Transmittal

PROJECT: Munjoy Hill PFD - Monopole

PROJECT No: 2612

Copies	Date	Description
1	05/17/12	Submittal No. 003A - Reinforcing Steel Dwg. No. R01

△ PROPOSED MODIFICATION TO SHOTCRETE WALL NO. 2 TO AVOID INTERFERENCE WITH EXISTING CONTROL JOINT

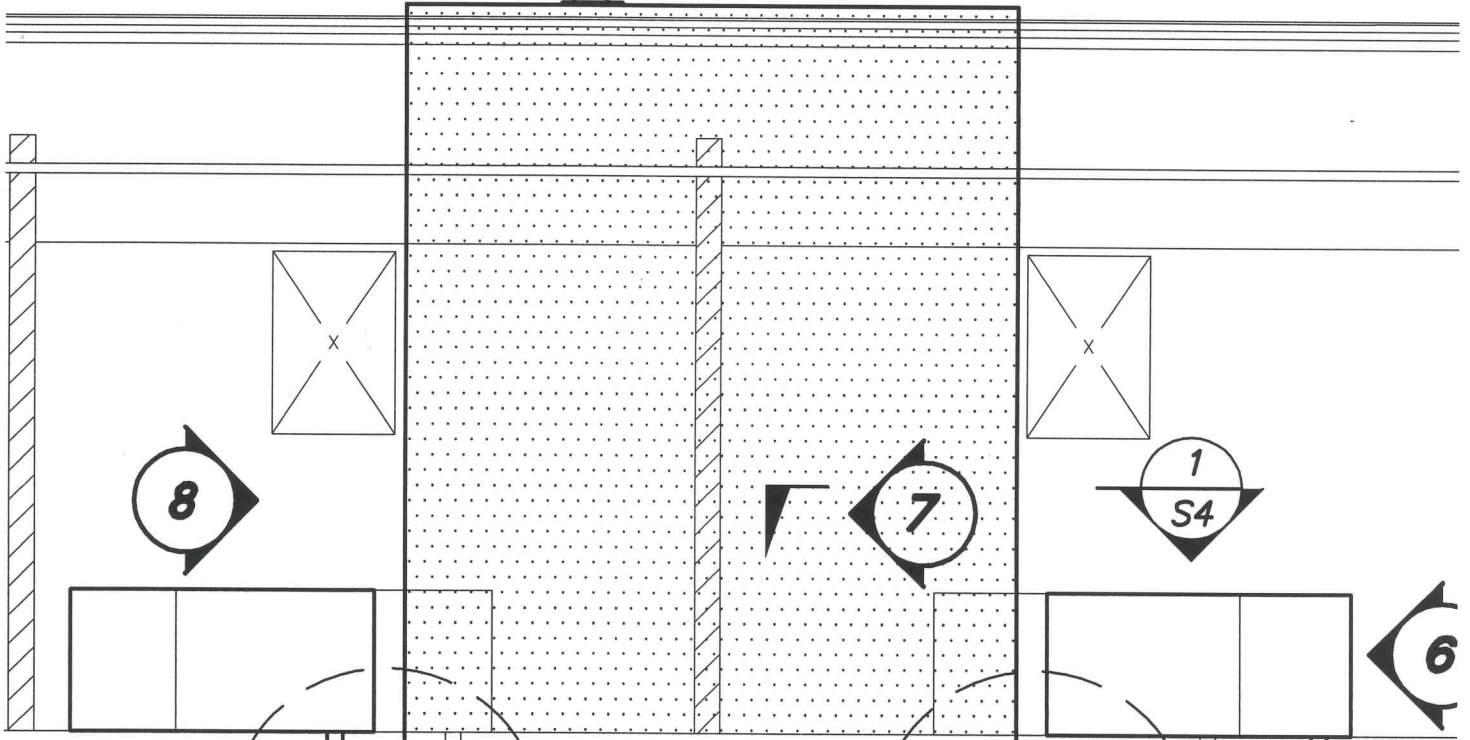
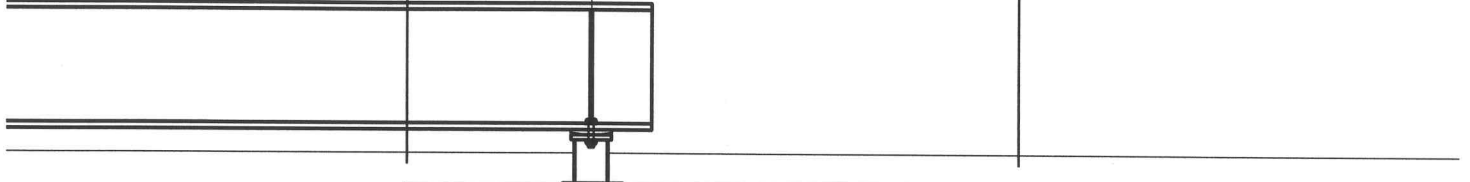
Please coordinate proposed length of shotcrete wall no. 2 with Barker Steel. See attached sketch depicting our understanding of the revised wall length to avoid interference with control joint at shotcrete wall no. 2. If this differs from field measured locations of the control joint please contact us before proceeding with the requested modification. Thanks.
